Darley Cliffe Hall – proposed extension

Revised Proposals

Drawing Title / Description  
**PROPOSED PLANS**

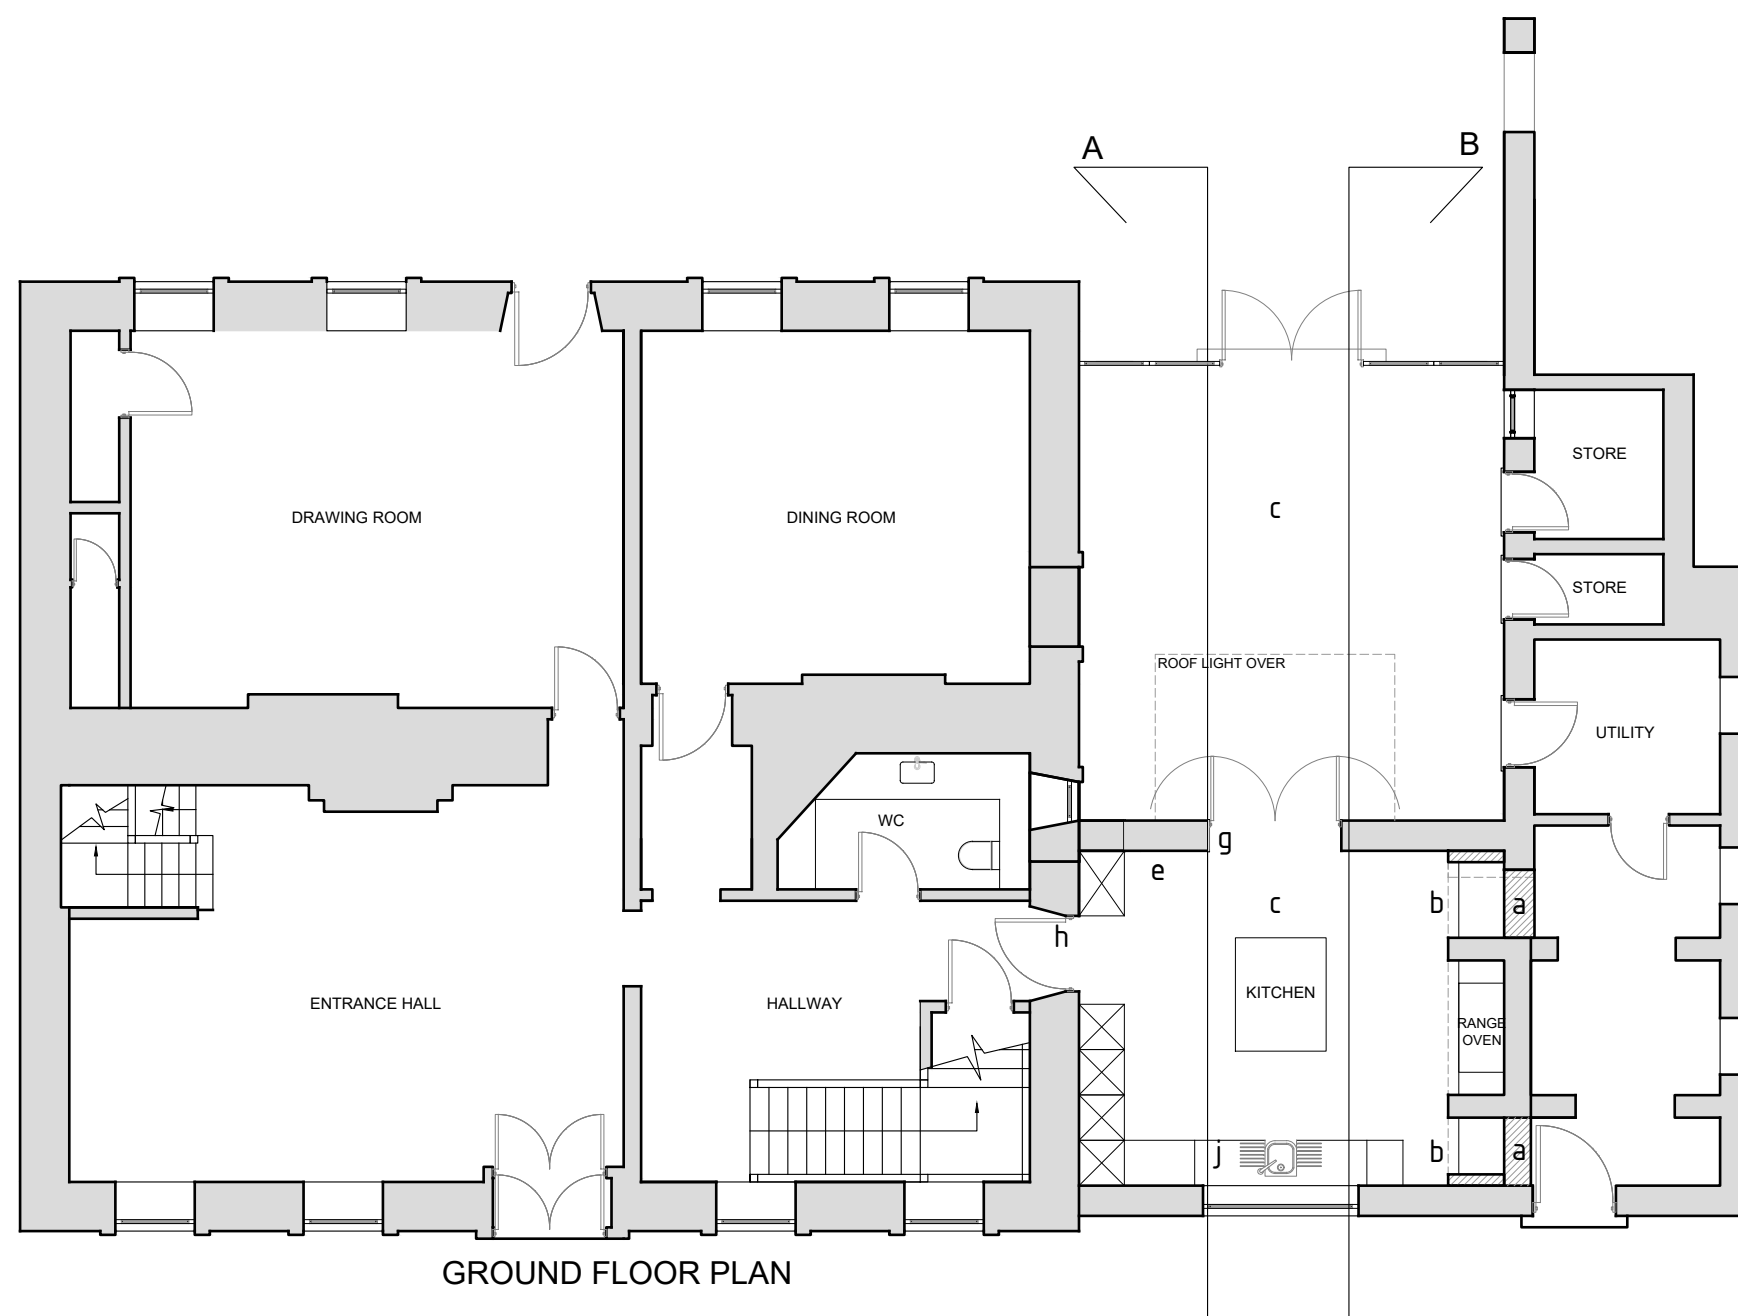
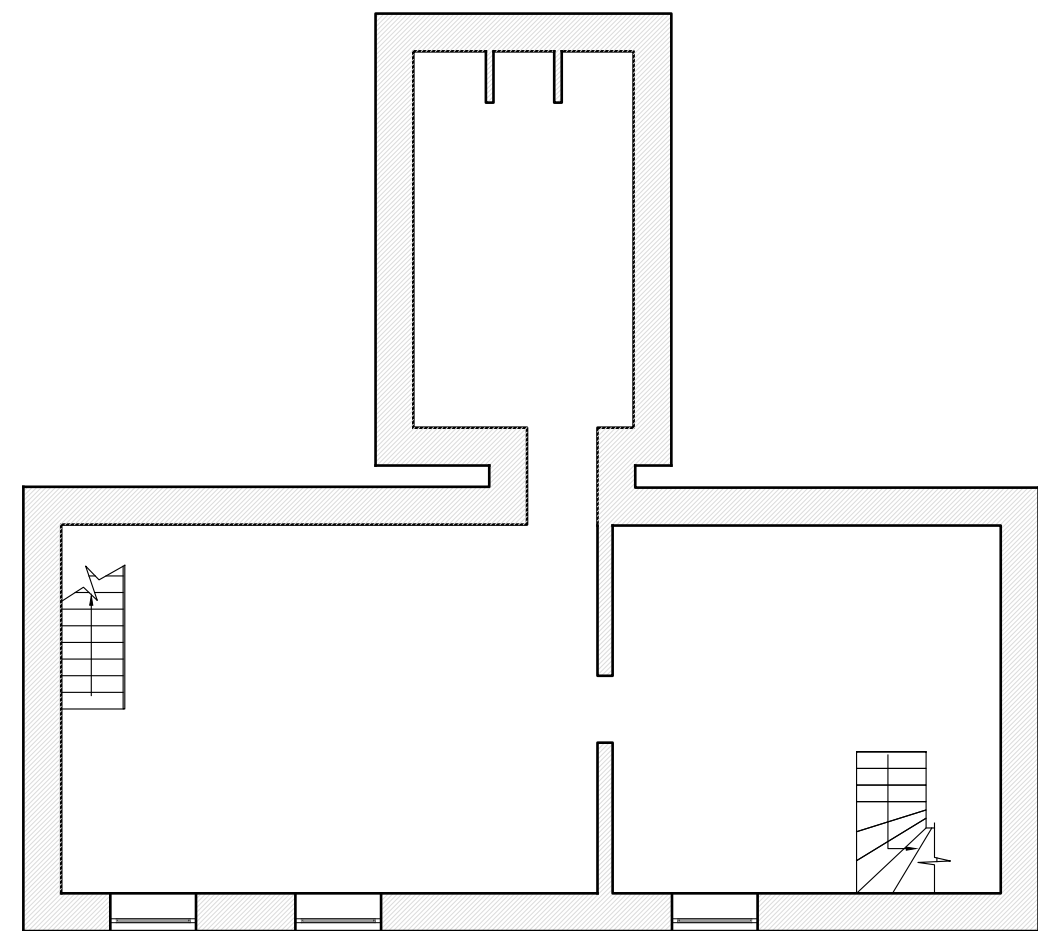
1. The design of the screen itself with no. 6 glazed panels did not reflect the 5-bay symmetry of the front façade. The use of small rectangular panels laid horizontally appeared over fussy and that the design of the screen needed reconsidering.

2. The position of the Screen wall was considered to be too far forward, and close to the corner of the front façade of the house. This was assessed as impacting negatively on it. It was suggested that the screen should be moved back from the front façade and to occupy a smaller floor area.

3. The proposed roof-light at the junction of the existing kitchen roof made it prominent and visually intrusive when viewed from the north side and front of the building.

4. Internally the blocked stone-framed window on the north side-elevation of the house, which formally lit the Dining Room, was partially cut across by the height of the roof with part inside, and part outside above the roof. In essence the internal ceiling (and roof) was not considered high enough.

Drawing Title / Description
PROPOSED PLANS

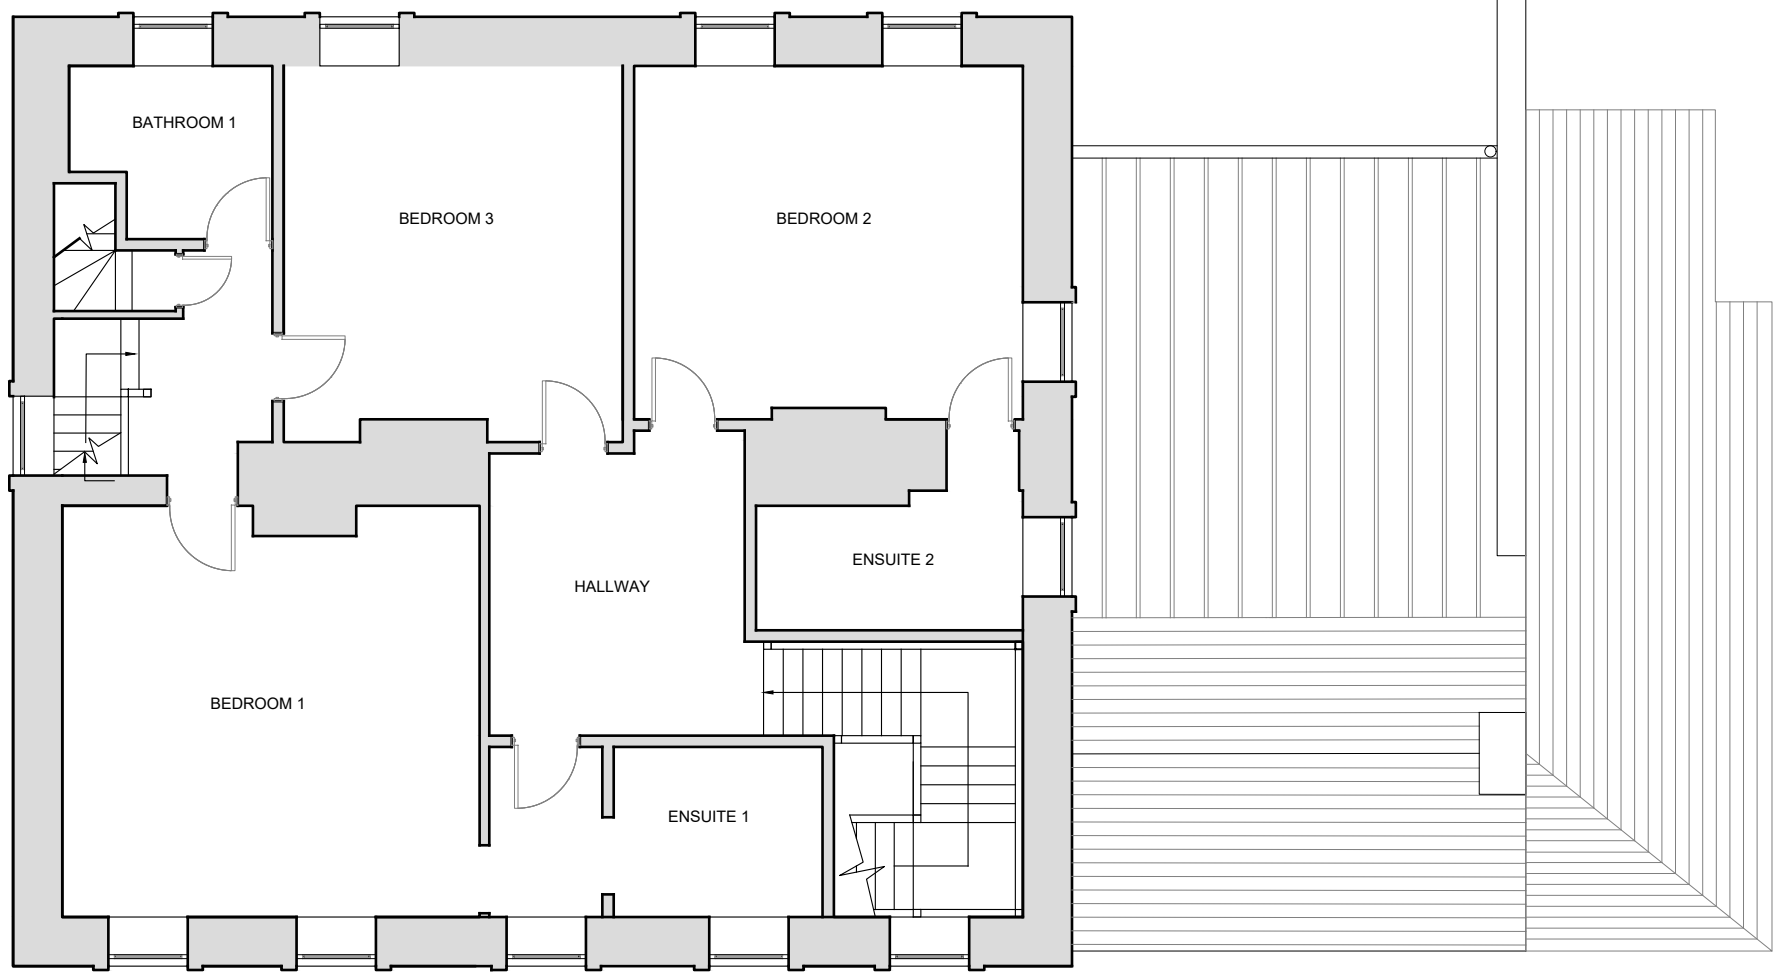
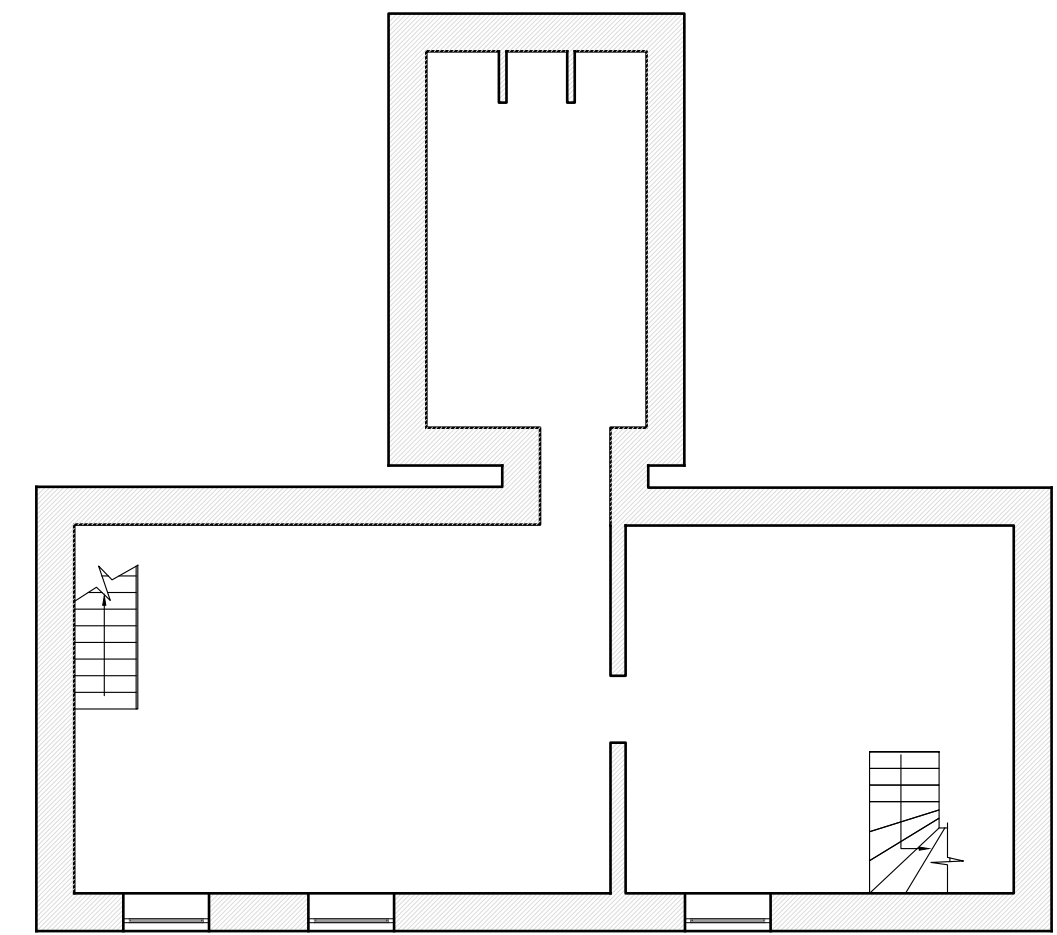
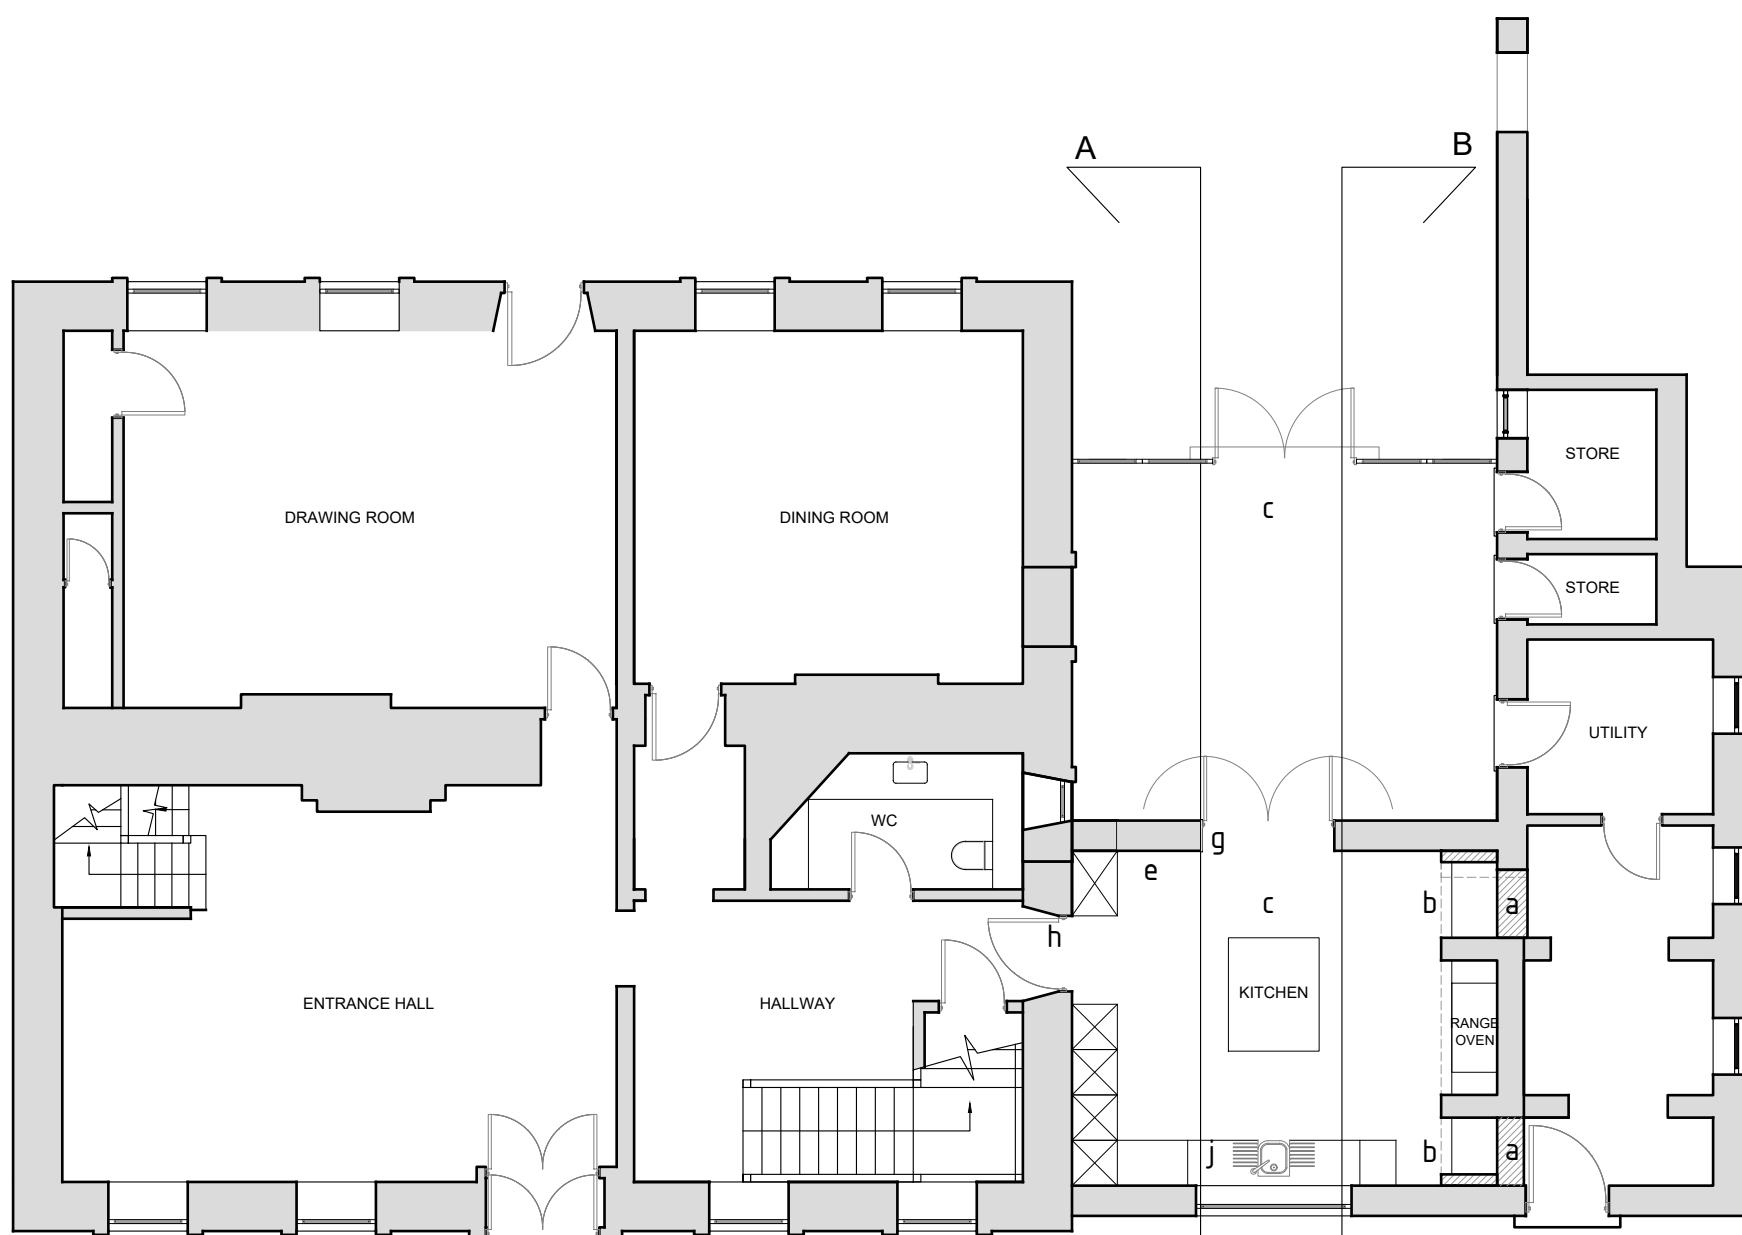
1. “The front elevation has too many windows. If you take out the central window of each group of 3, and rebalance them as two windows to either side of the central

French doors you have a Georgian 5 –bay symmetrical façade like the house – better keeping with Classical proportions.

2. The new front looks a bit too low and squat. I recommend that a moulded cornice and ashlar parapet upstand is added above the windows, which should mask the view of the roof.

3. The whole building could be slightly taller I think,
4. Re. the visible part of the blocked window that I suggested (only today) could be opened up as a linking door to-and-from the Dining Room. The bit showing above the roof could be glazed as an over-light / fan-light. Or it could copy the upper part of the sash window (6-paned) at the first floor. This would then let in natural light into the side wall of the Dining Room and be the same size as the windows in the garden front elevation when viewed from inside of the dining room. The new doorway (with a part-glazed door) could form a useful connection for bringing food from the Kitchen, rather than through the main Stair Hall. Also it would keep guests out of the Kitchen So what you are really creating is a Breakfast Room with perhaps just a small cooking area / servery positioned just outside of the existing kitchen wall. This means really confining the actual kitchen units, fridges and cooking area to where it is, but maybe removing some of the door openings on the north side so it becomes less of a corridor".

In response to these comments PBA have reconsidered the design and the position of the screen that is now considered to be more appropriate with 5 large glazed bay divisions, simplified and preened of any fussiness and set back sufficiently so as to reduce its impact and any visually intrusion on the garden front elevation of the house. The screen height has been increased so that the roof sits above the window-head entirely within the extension, rather than part of it outside of its height. The troublesome roof-light has now been totally removed as it is no longer considered necessary due to the increased level of day-light provided by the new screen in the extension. The roof design has been simplified to meet modern constructional practices designed to cause least impact on the historic building utilising tern-coated stainless-steel much favoured for replacing stolen lead roofs from listed church roofs – initially shiny it soon dulls down to a mat grey colour, not unlike lead. See: <https://twitter.com/aperamuk/status/666254451376791552>
